Subject: RE: Springfield, Hook Lane - AL/64/20/PL

The Engineering Details Drainage Strategy for the site as illustrated (dwg. no. 602-01, Rev C) is broadly respectful of retained trees and their growth potential, with the obvious exception being chosen route of surface water discharge to the north boundary watercourse and construction of headwall – both within the RPA of retained (off-site?) mature Cypress T21. Directional drilling technique is proposed 'if required'. I say it is necessary unless exploratory excavation findings permit standard trenching. All that to be set out in the required Arboricultural (Impact Assessment &) Method Statement. ***Might it not be easier to take a more northerly route from manhole S8 and avoid significant tree's (T18 & T21) RPA altogether***, subject to suitable ground levels (gravity connection)?

Drainage Strategy				Draining The
Engineering Details				
Drawn	Checked	Scales	Paper Size	Date
JN		1:250	A1	08.19
Job No.				Revision
KNC/1932	602-01			C

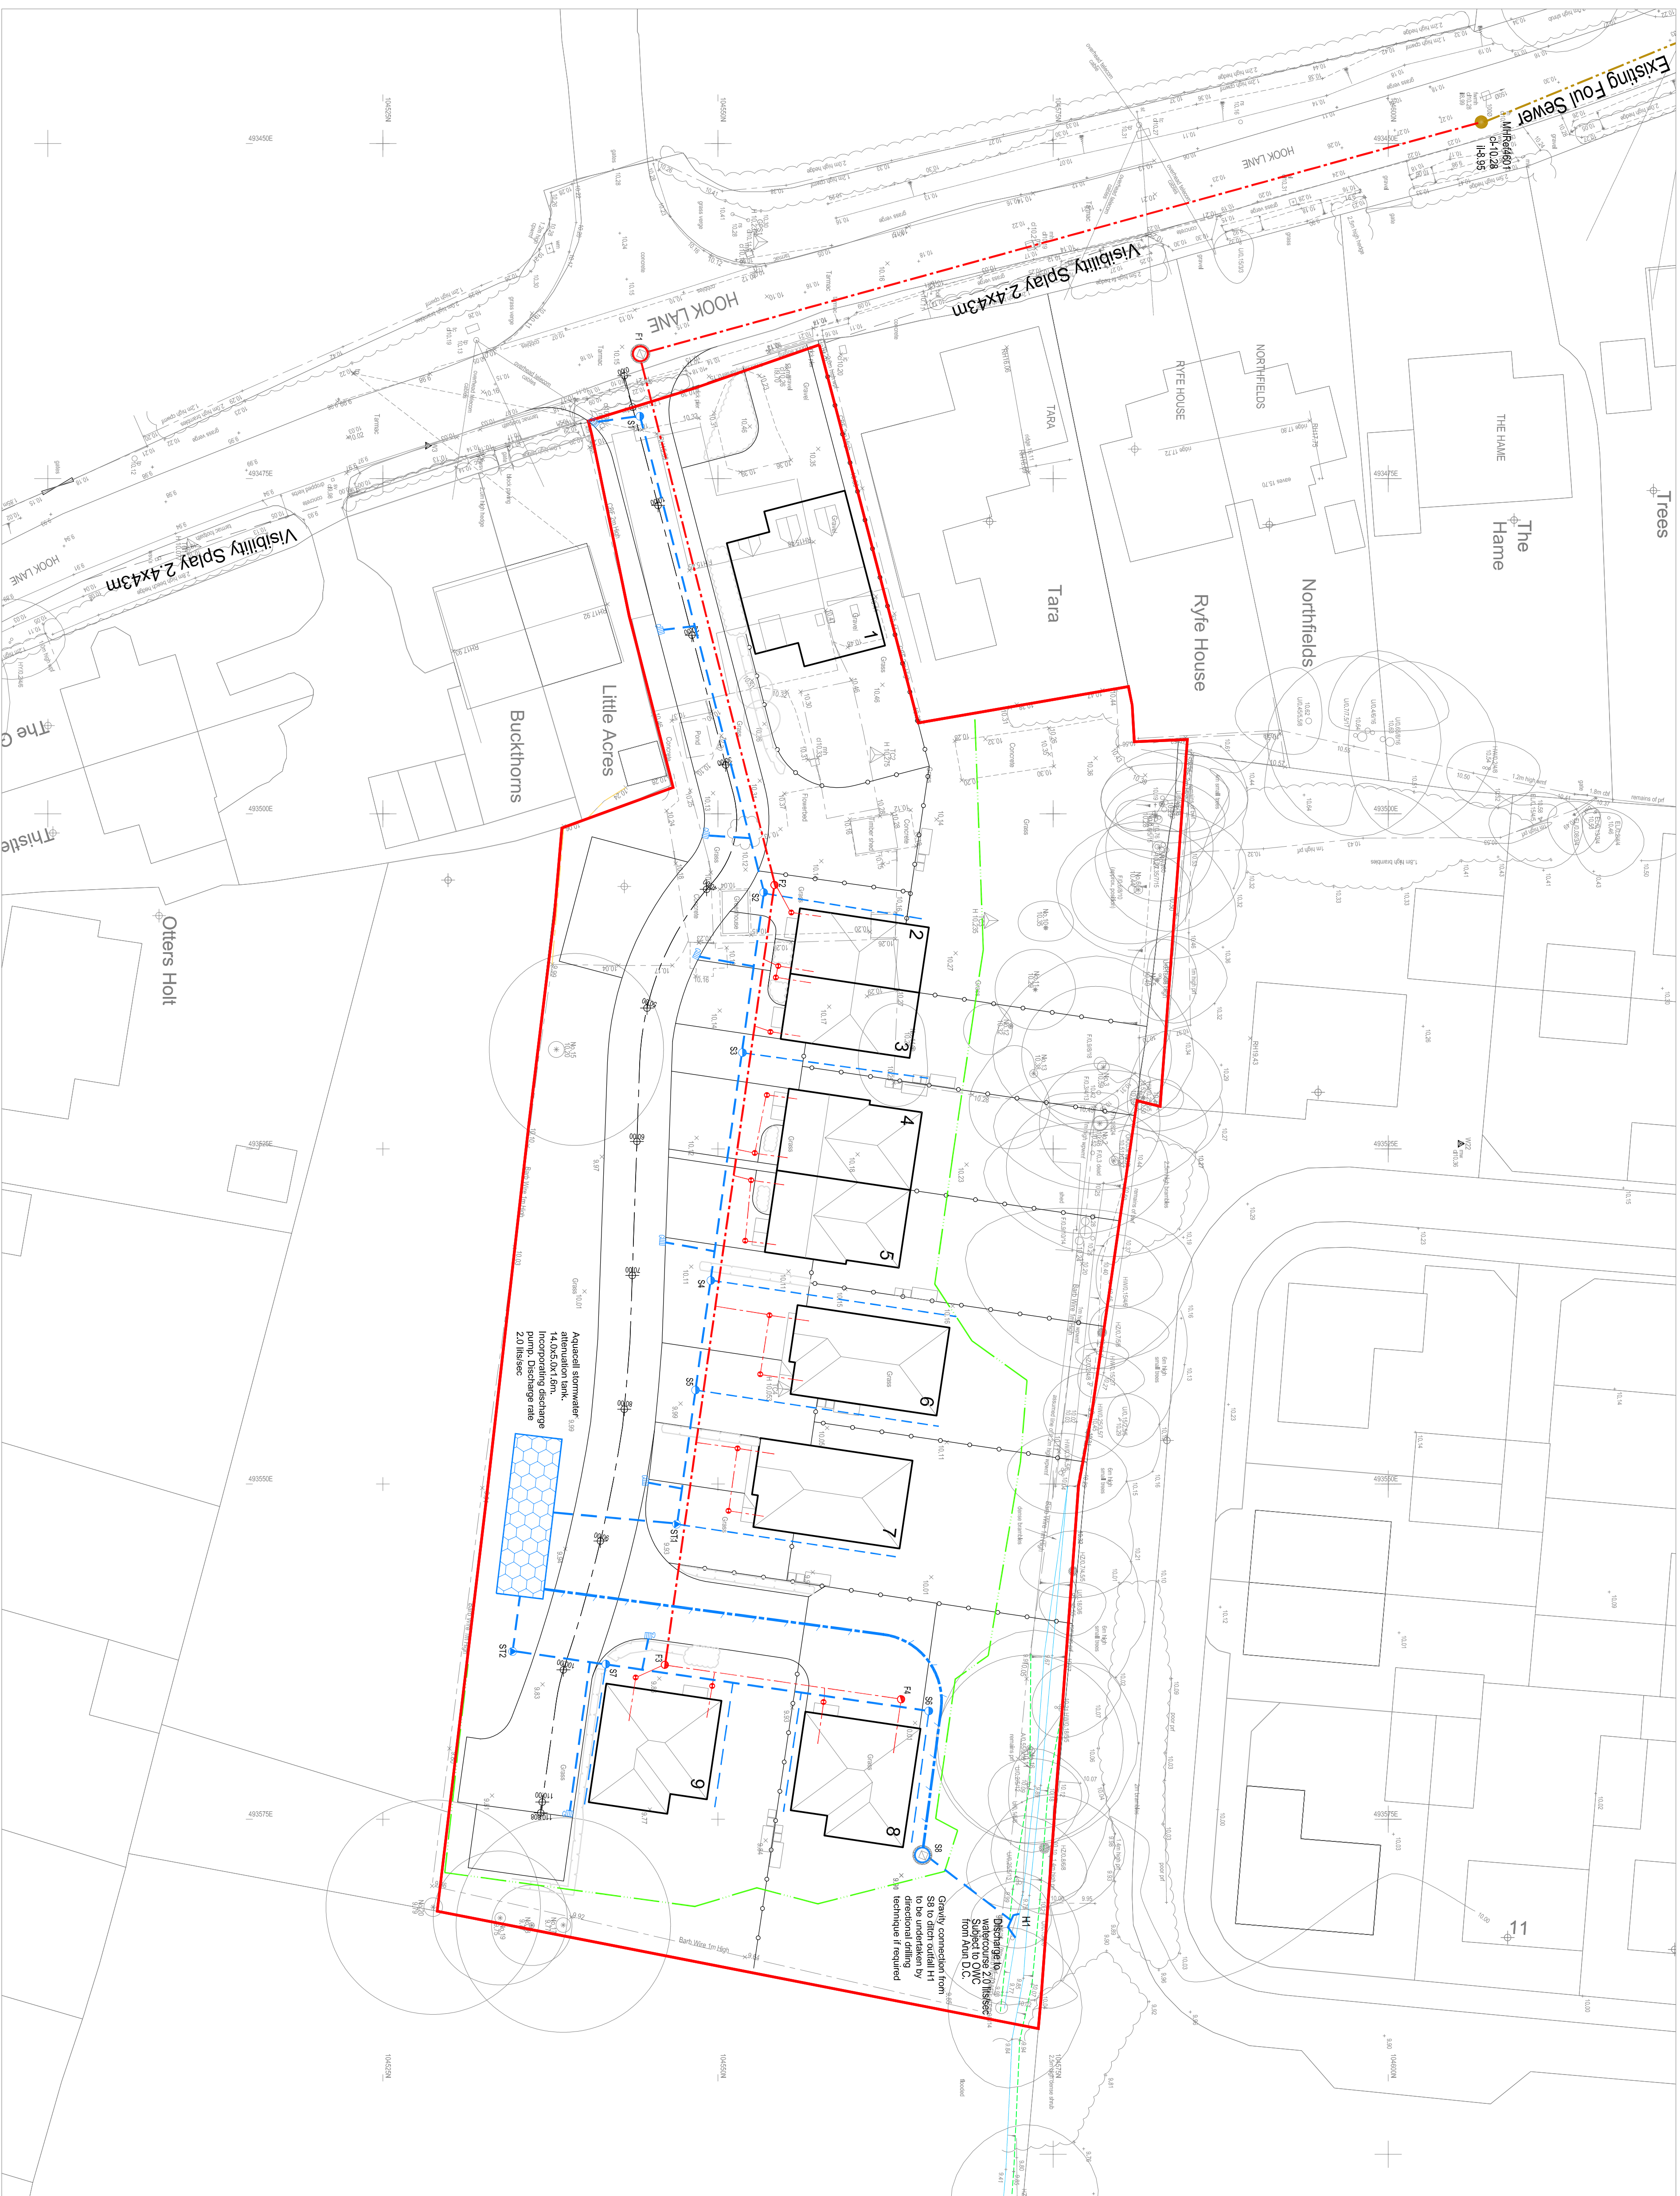
I have highlighted the relevant part regarding the suggested re-routing of the drainage run as whilst we appreciate the drainage is currently shown heading north-east from manhole S8 and would be within the edge of the RPZ of T21 (circled in orange) if we move the drainage run to a more northerly position from S8 (orange arrow) as suggested this would encroach more within the RPZ of T18, which I believe is a Category B tree (T21 being a C category tree). We are keen to work with you to make revisions and at present the drainage scheme is only indicative however we want to make sure any changes address Mark's concerns in order to present the application with the best chance of success before Committee. As such we would be grateful for any comments you may have in this regard.

- (1) You amend the Method Statement to make it implicit that exploratory excavation will be carried out and if roots are present along the drainage channel line then directional drilling to take place; or
- (2) You take a new drainage run in a northerly direction (not quite straight north) and aim to bisect the RPAs of onsite T18 and offsite T21.
